From:
Sent: 10 September 2023 17:41
To: DCAdmin
Cc:
Subject: application number 2023/92128 at location Church of the Holy Innocents, Vicarage Road, Dewsbury, WF12 9PD

Holy Innocents, Vicarage Road, Dewsbury 2023/92128

| Rev                          | Date | Details | Drawn       | Checked |
|------------------------------|------|---------|-------------|---------|
| Dewsbury, WF12 9PD           |      |         | A18         |         |

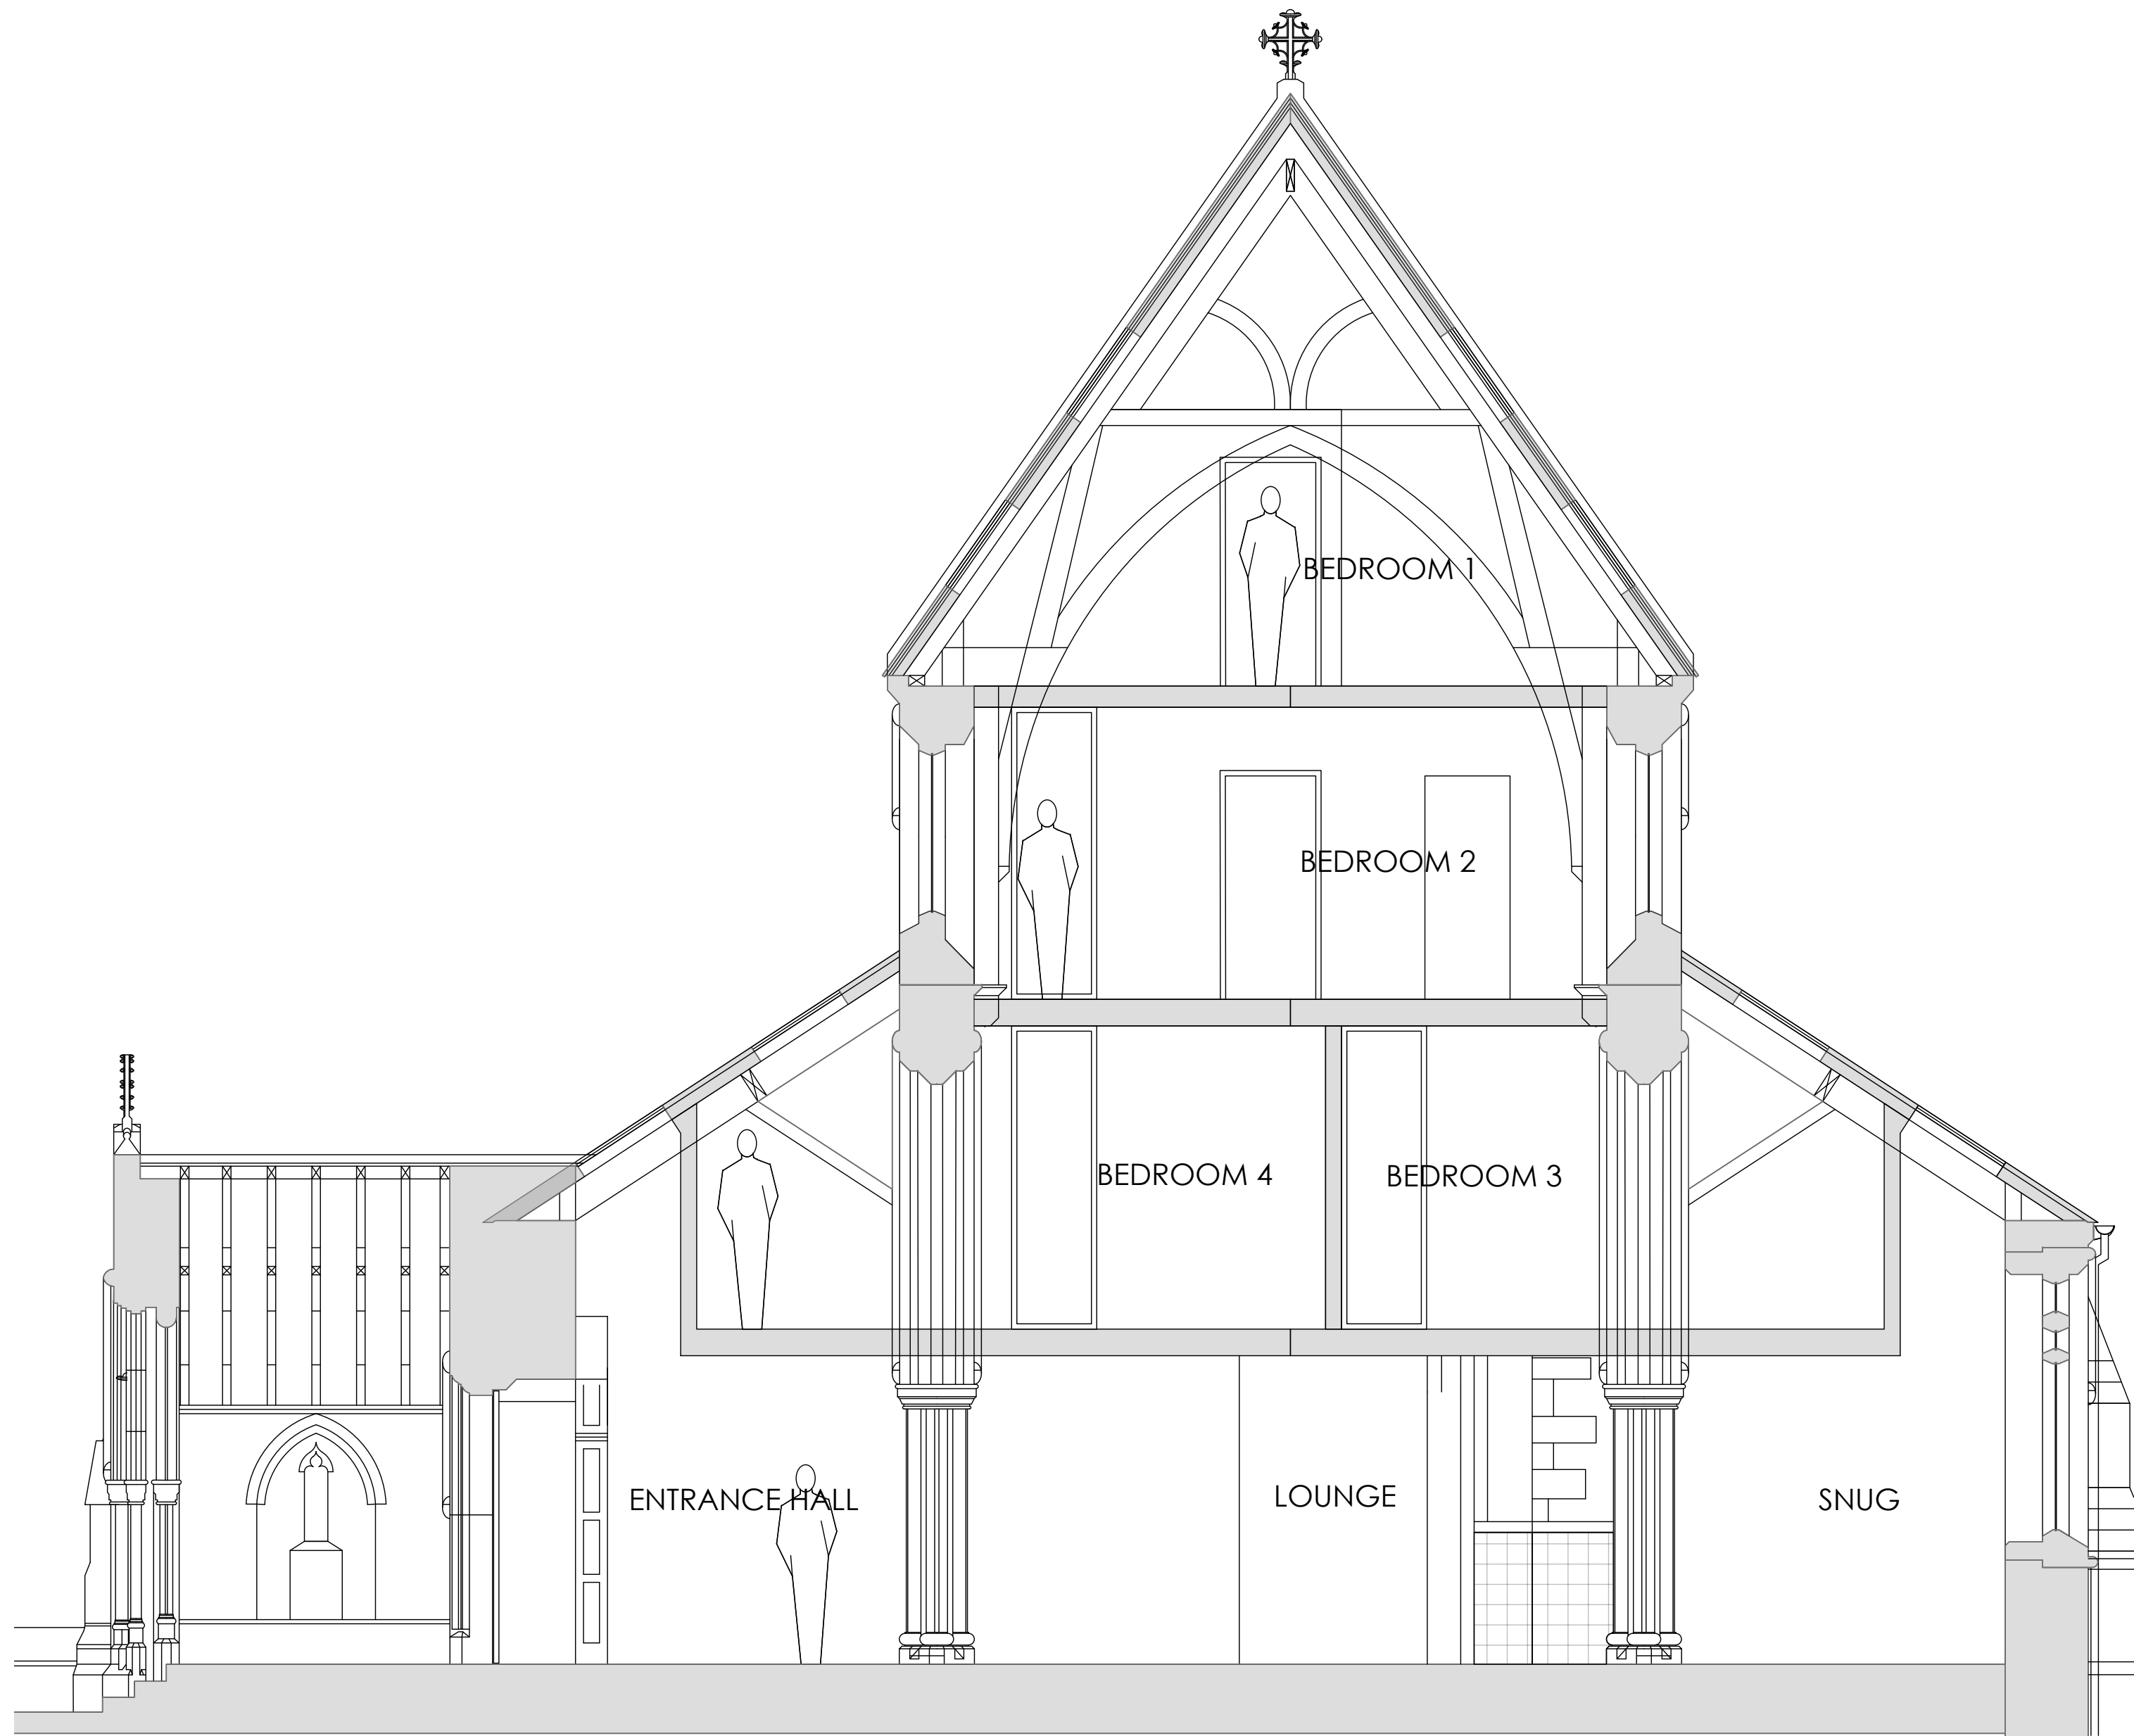
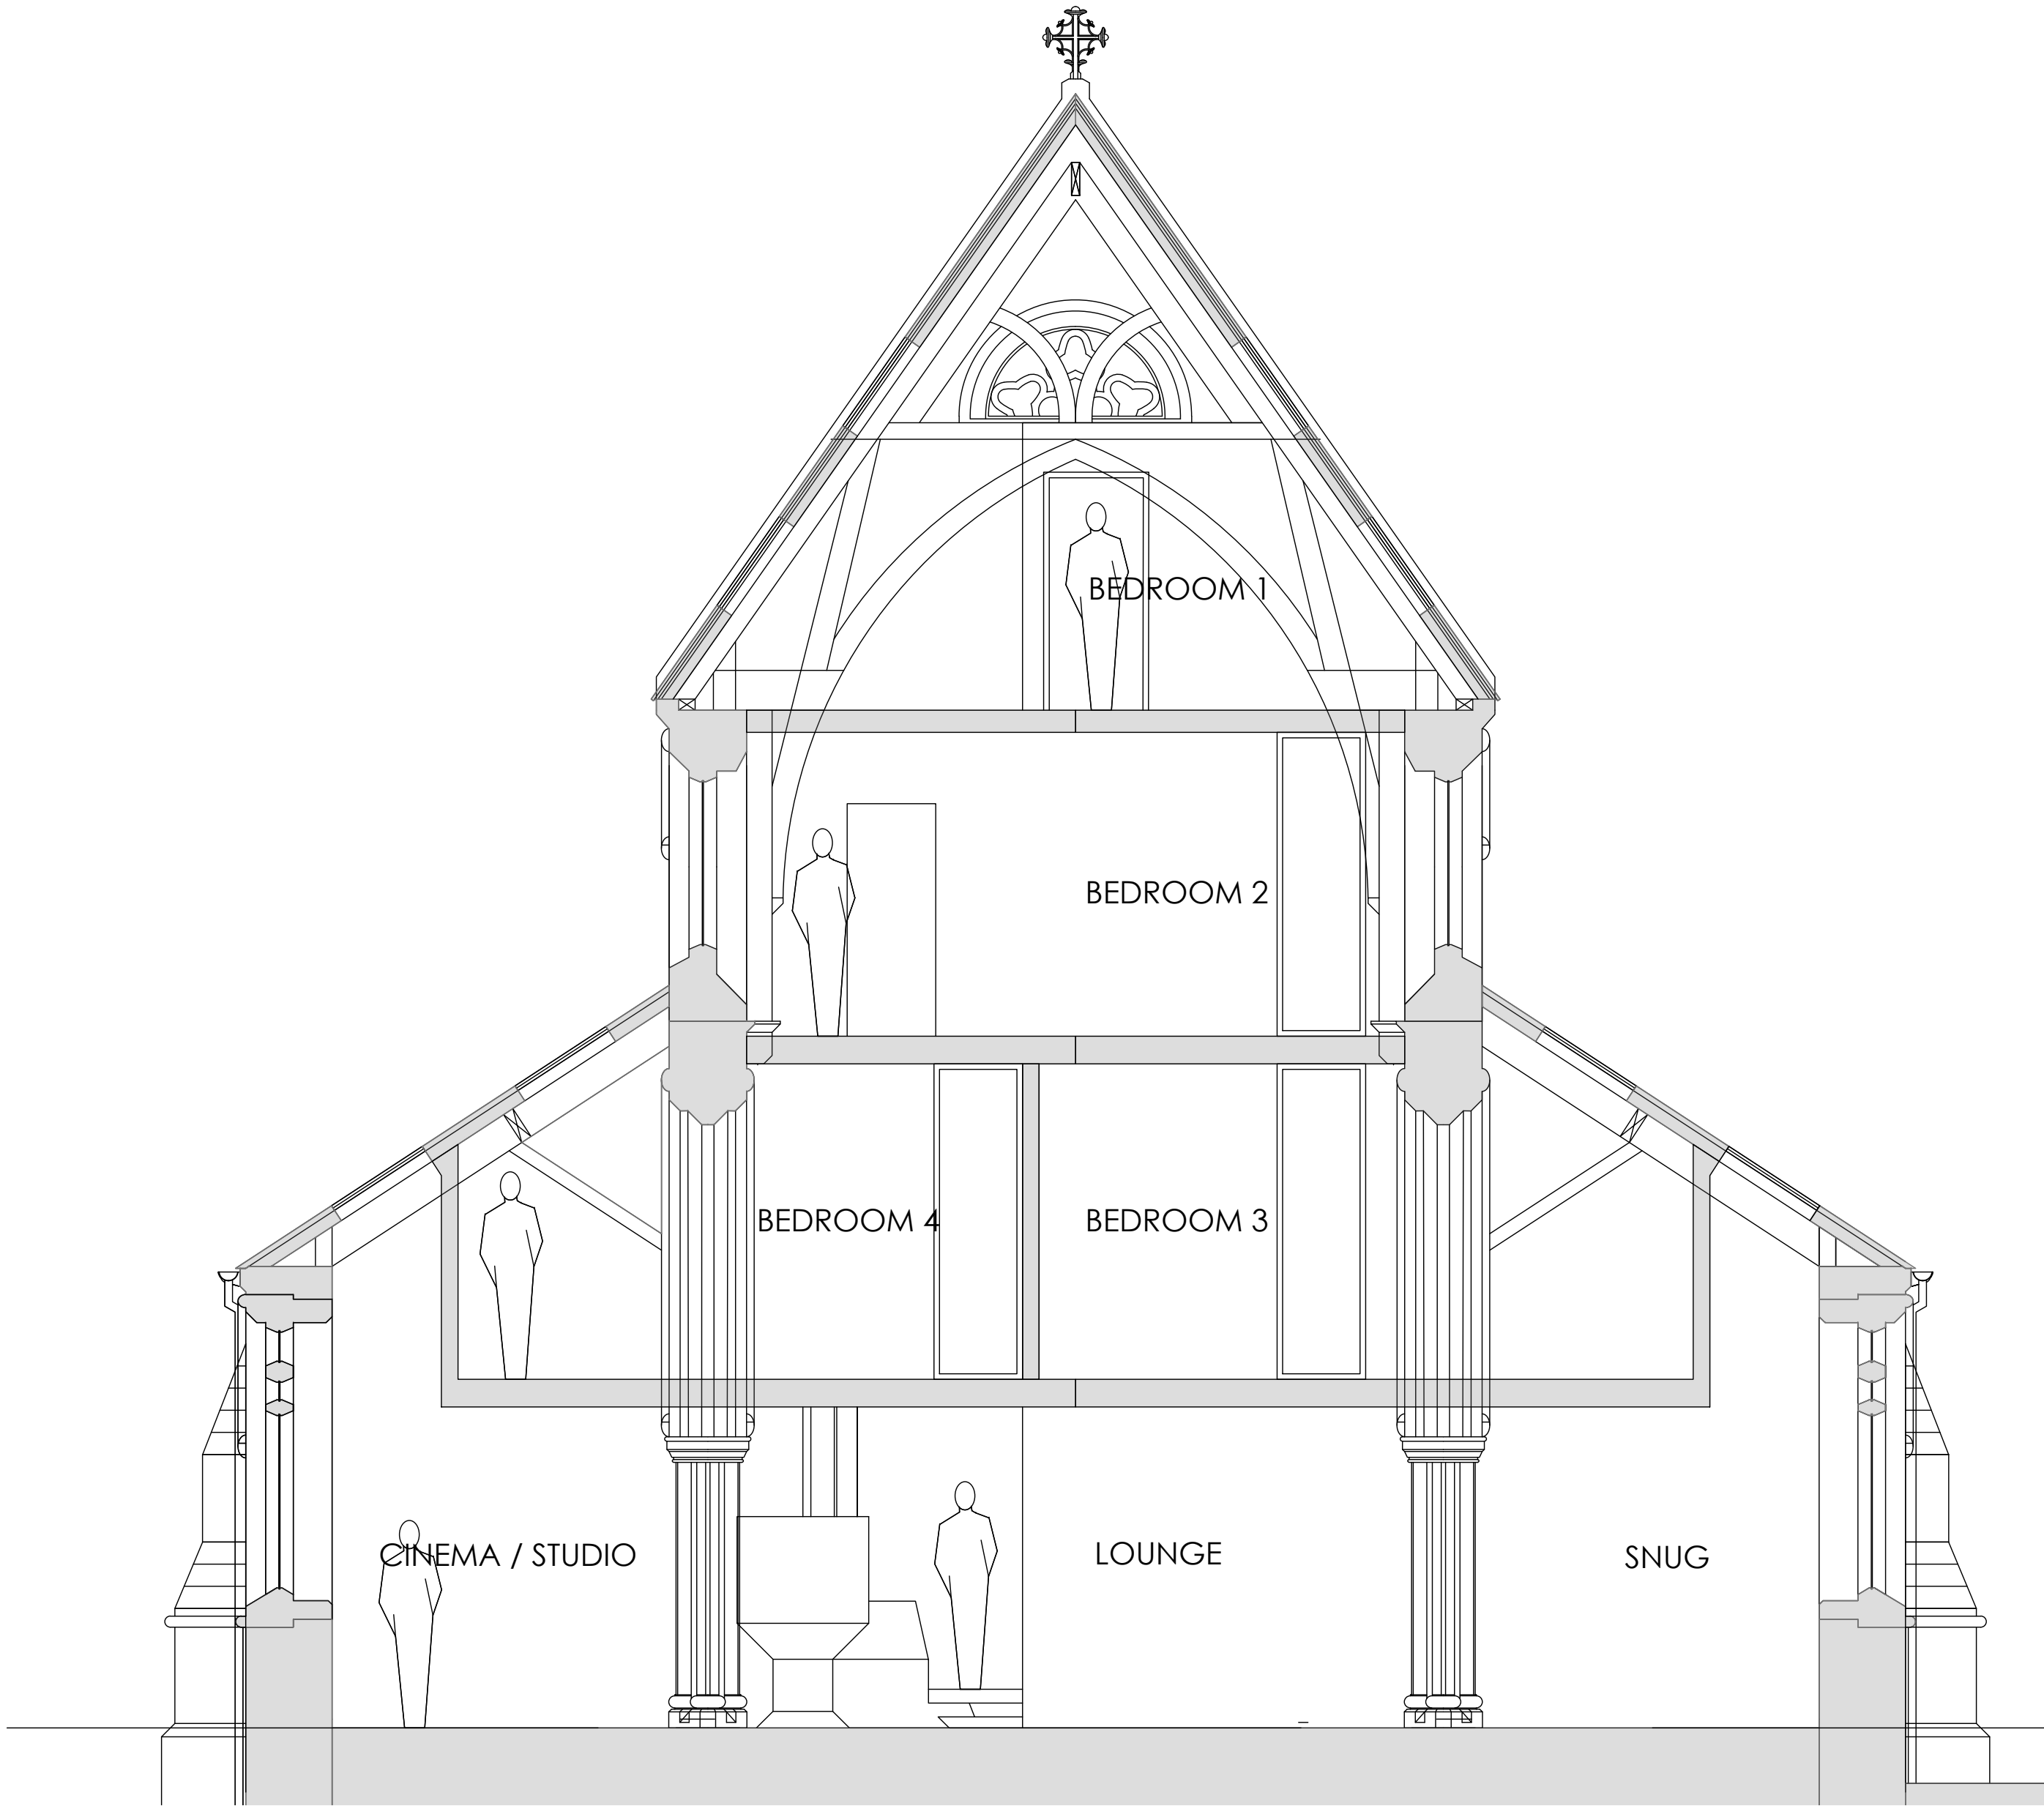
2. The holiest and richest part of the building is the chancel and sanctuary to the East. It was this section of the interior that cries out to be preserved intact. I cannot find any confirmation on Drawing A13 that any of the choirstalls, the reredos or encaustic floor tiles are to stay, although the section (Drawing A17) implies that the reredos and organ pipes are to remain. Drawing A11 refers to the retention of the organ but the base including the console and return panelling appears to go.

Can it be spelt out expressly what is and is not to stay in the chancel?
